Your Ref: OWQC16229
Our Ref: EP/138/17/PL
Please ask for:
Mrs A Gardner

13th November 2017

Demolition of existing buildings & erection of 3 No. dwellings with associated parking,
alterations to existing access & relocation of staircase to flats.

Land Rear of Beechlands Cottages Beechlands Close East Preston

Proposed Site Plan, Block Plan
and Location Plan

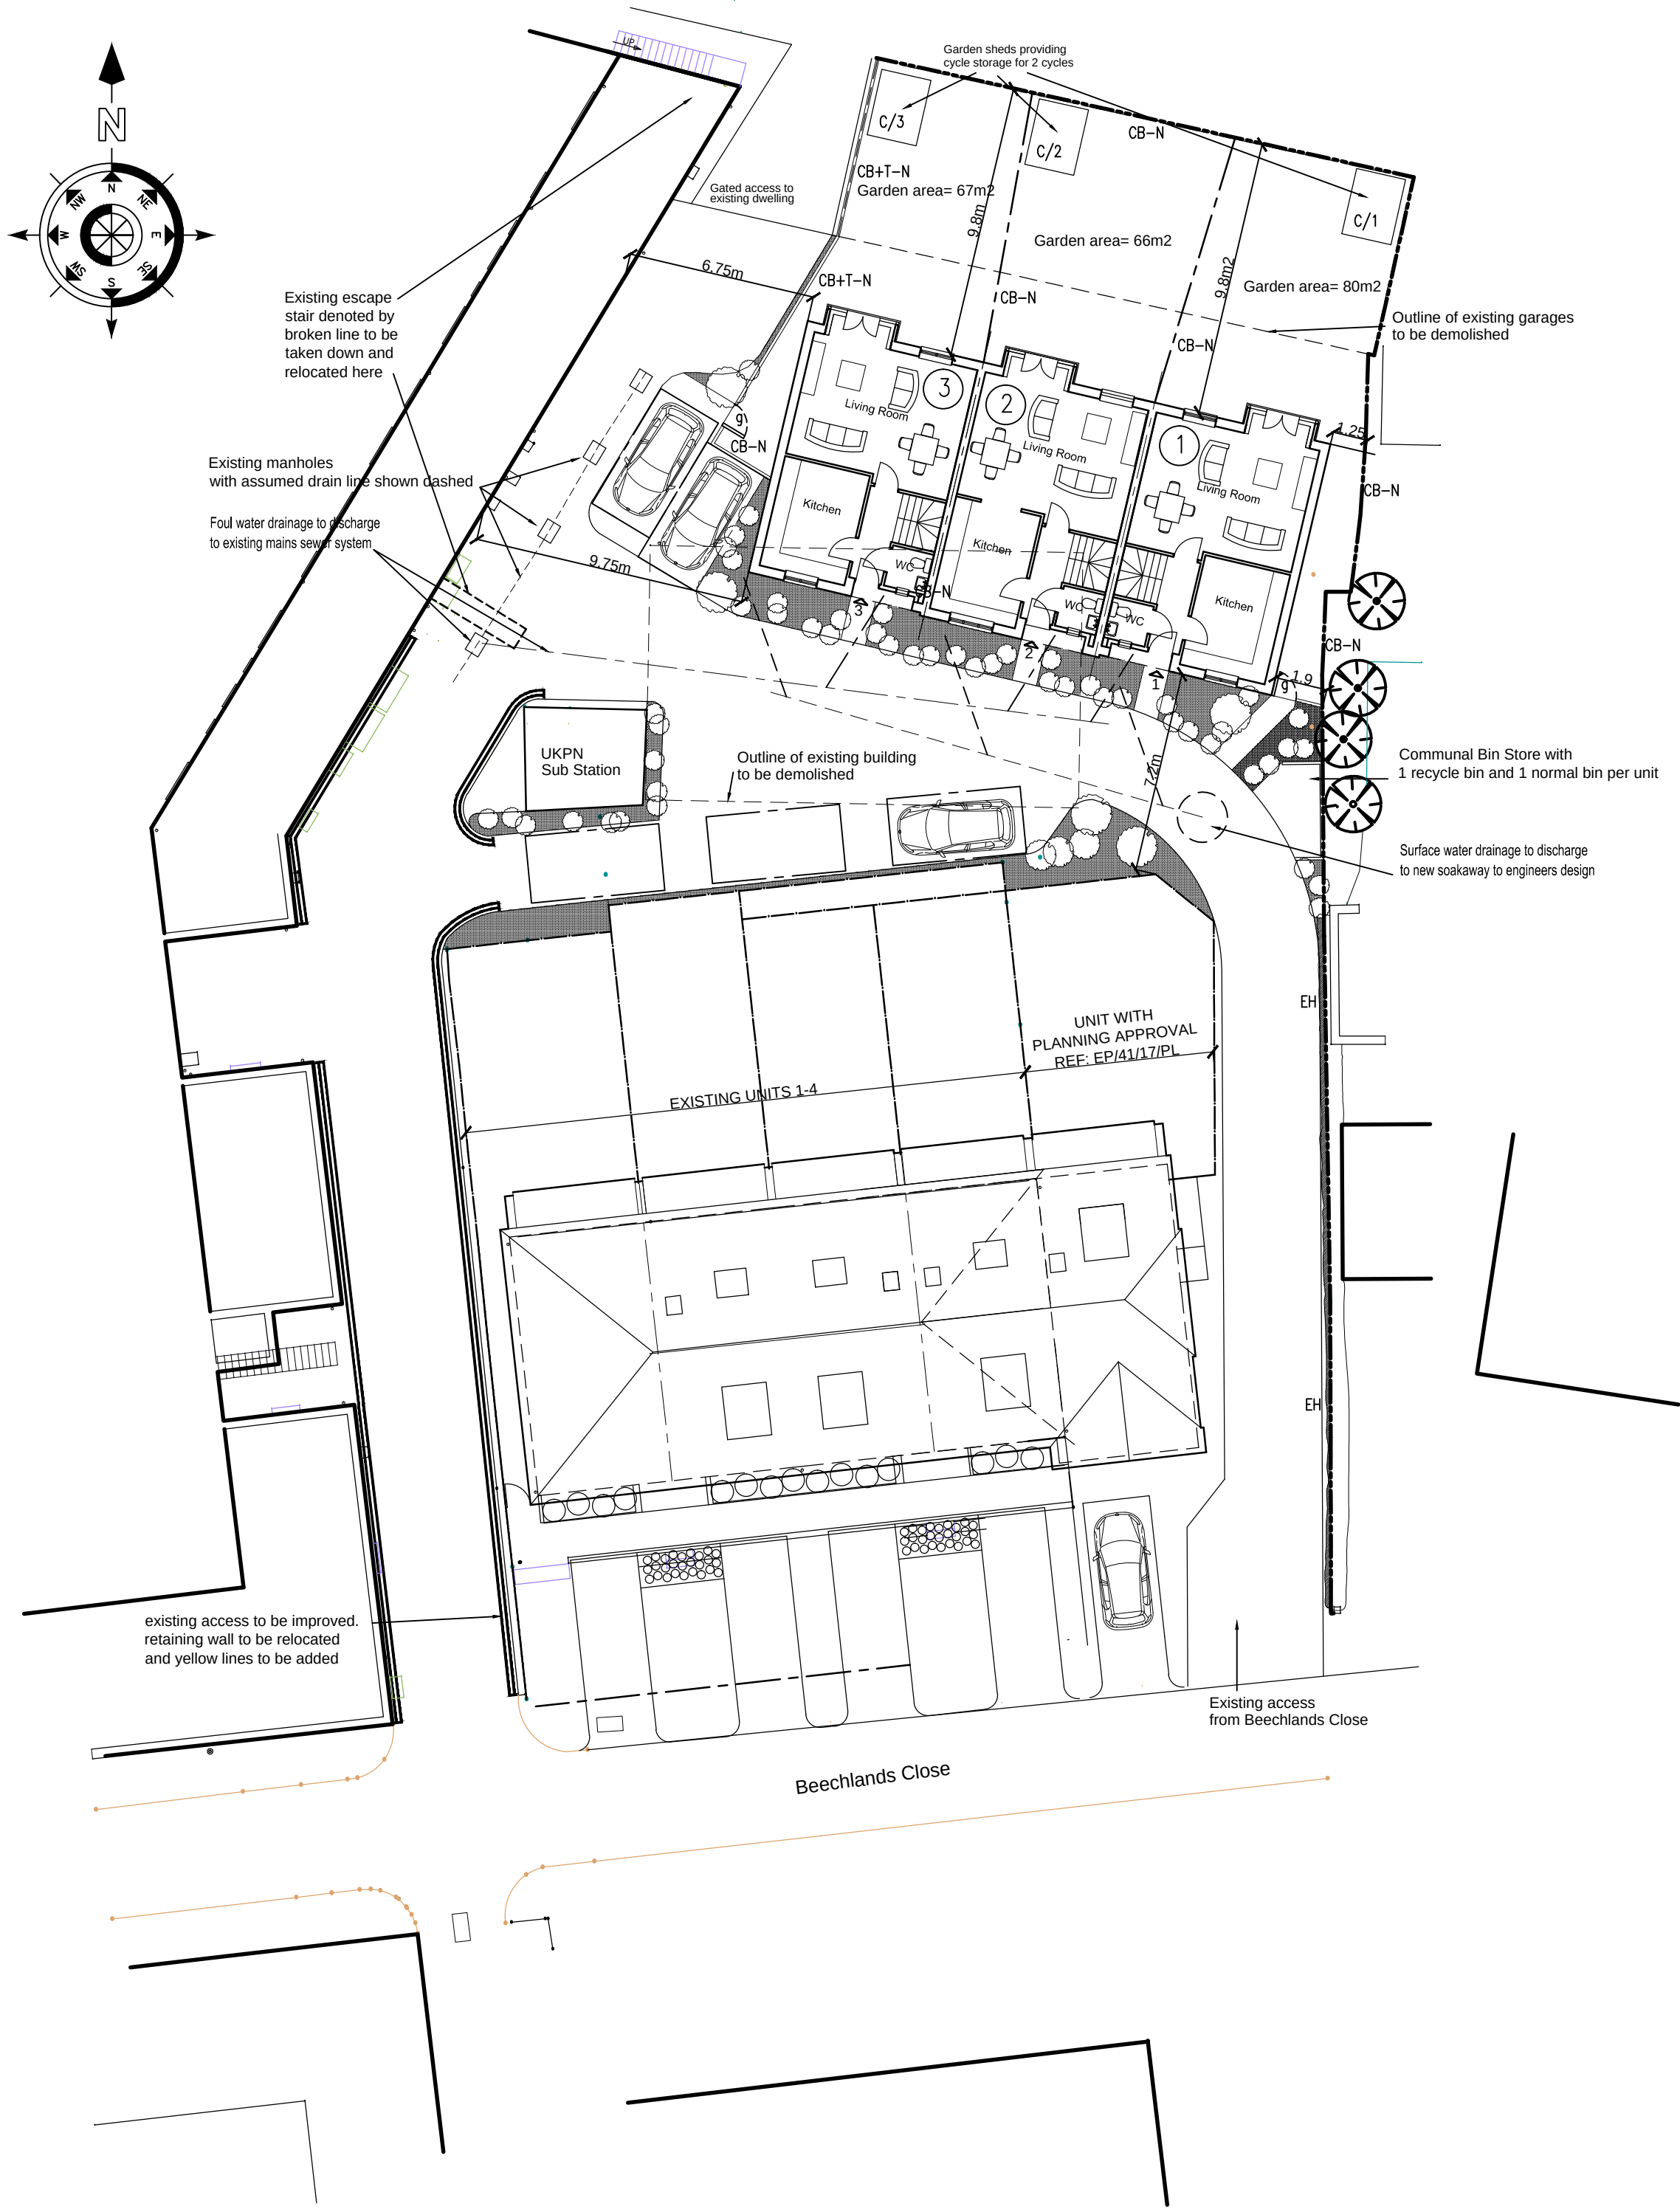
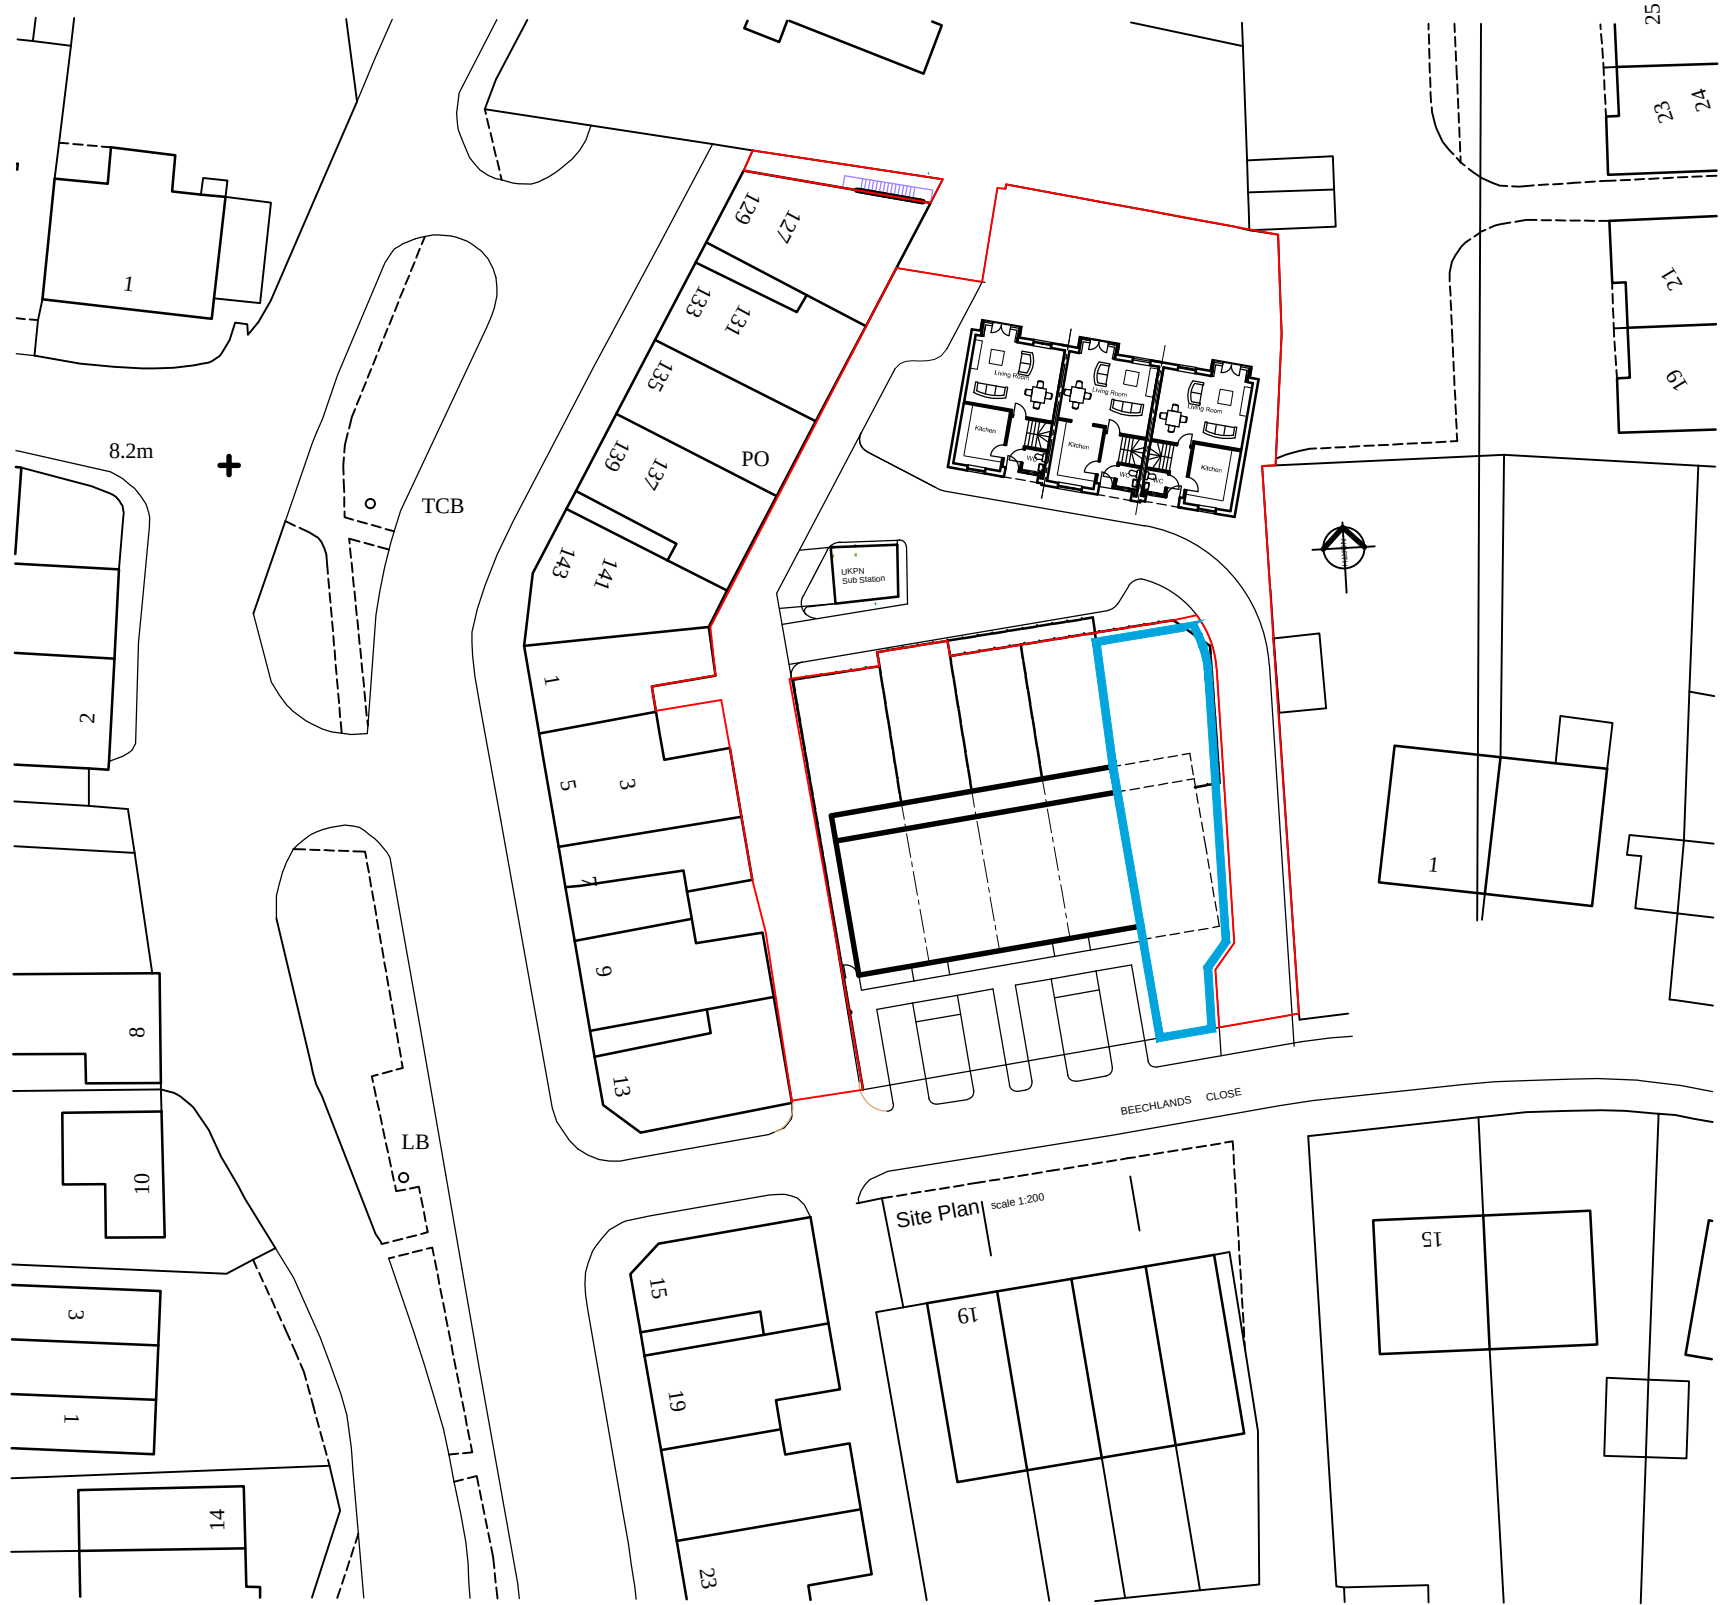
The committee was concerned about the provision of just five parking spaces, one of which to the south of the sub station appears to be impossible to use, appears to have no room for doors to open or people to walk alongside the vehicle. The plans suggest a total of fifteen people could live in these properties regardless of parking calculators, is it realistic to believe those fifteen people may only have five cars between them? If the proposal went ahead, existing car-parking would be lost in an area in which on-street parking is already at a premium.

DRAWING TITLE
Proposed Plans and Elevations

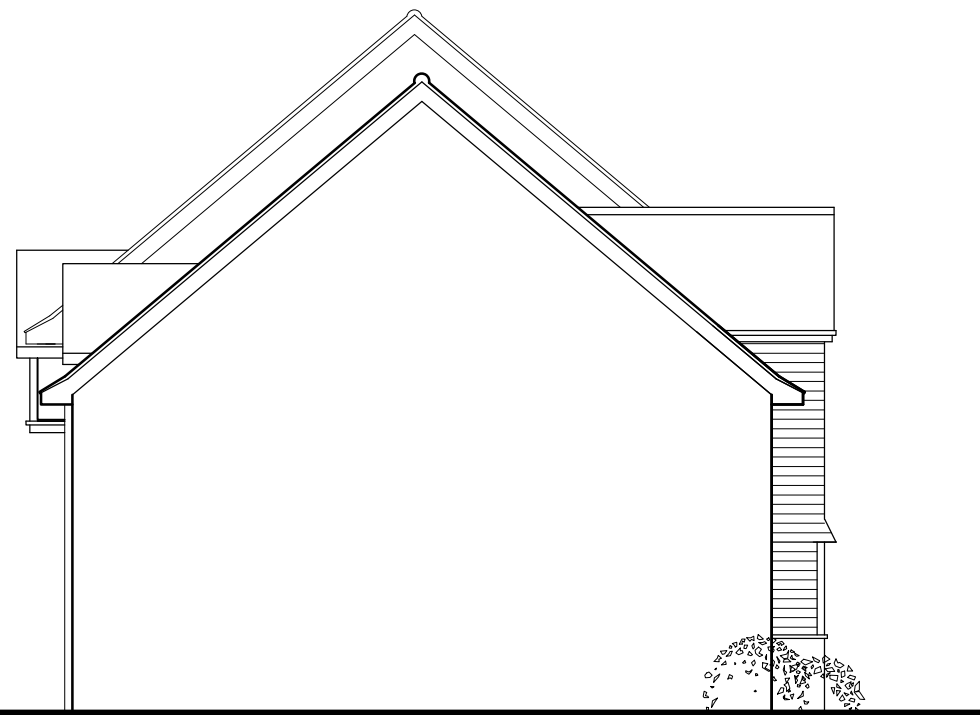
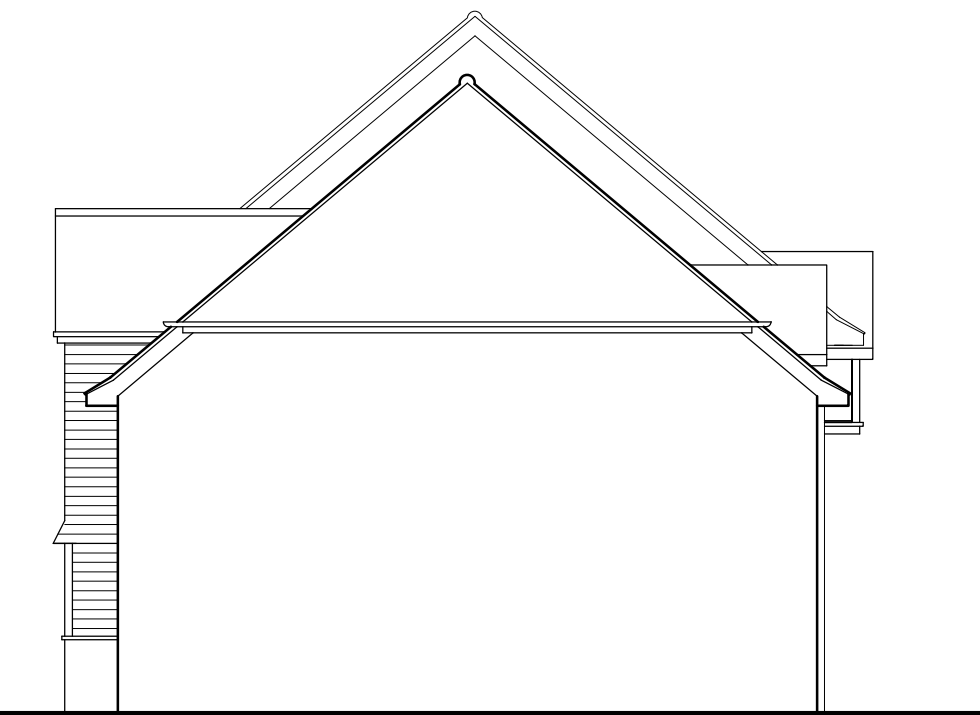
The committee felt the design of the building was contrary to the National Planning Policy Framework as there seems to be no reason for the two ends of the building not to be the same shape. Section 64 of the NPPF states Permission should be refused for development of poor design .

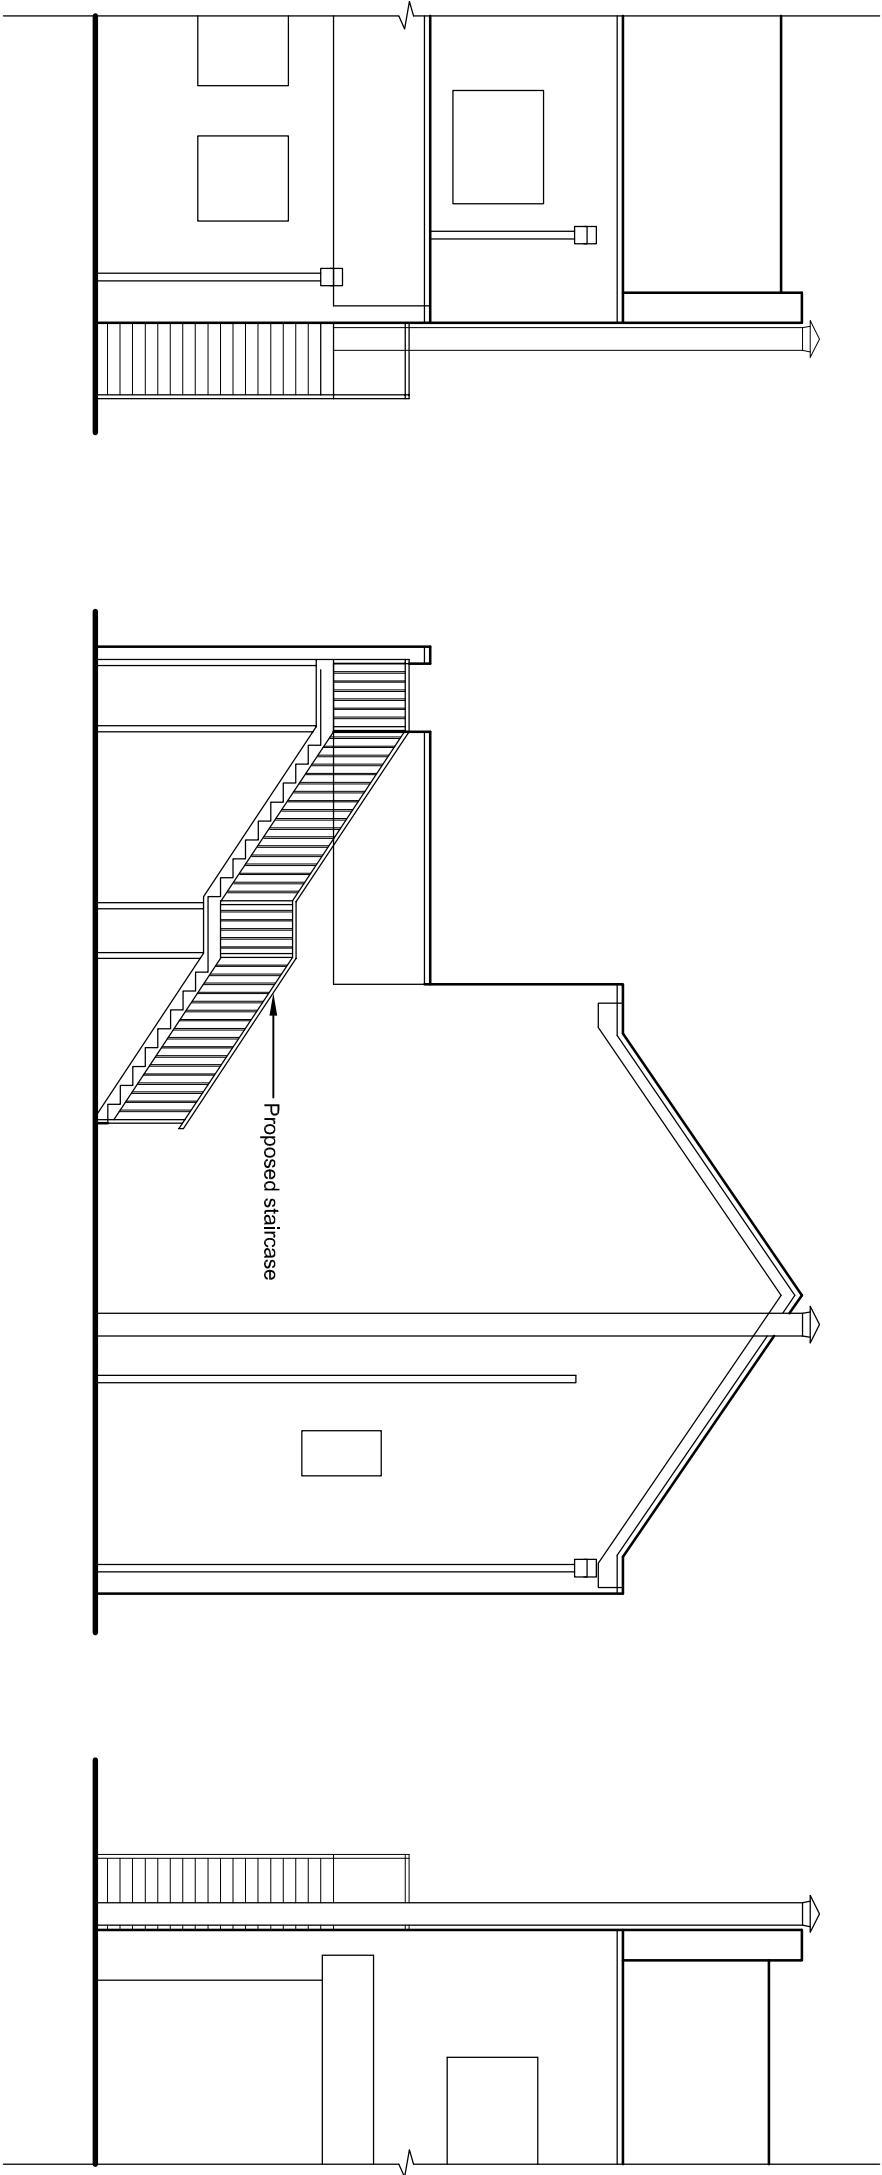
The committee was also concerned about the ability for emergency vehicles to access the site, not only the proposed new properties but also the rear of the existing flats above the shops in North Lane/Sea Road. The committee was concerned about emergency exit for the residents of the flats above these shops if the escape staircase is moved to one end of the building this will be an unnecessarily long route for some residents.
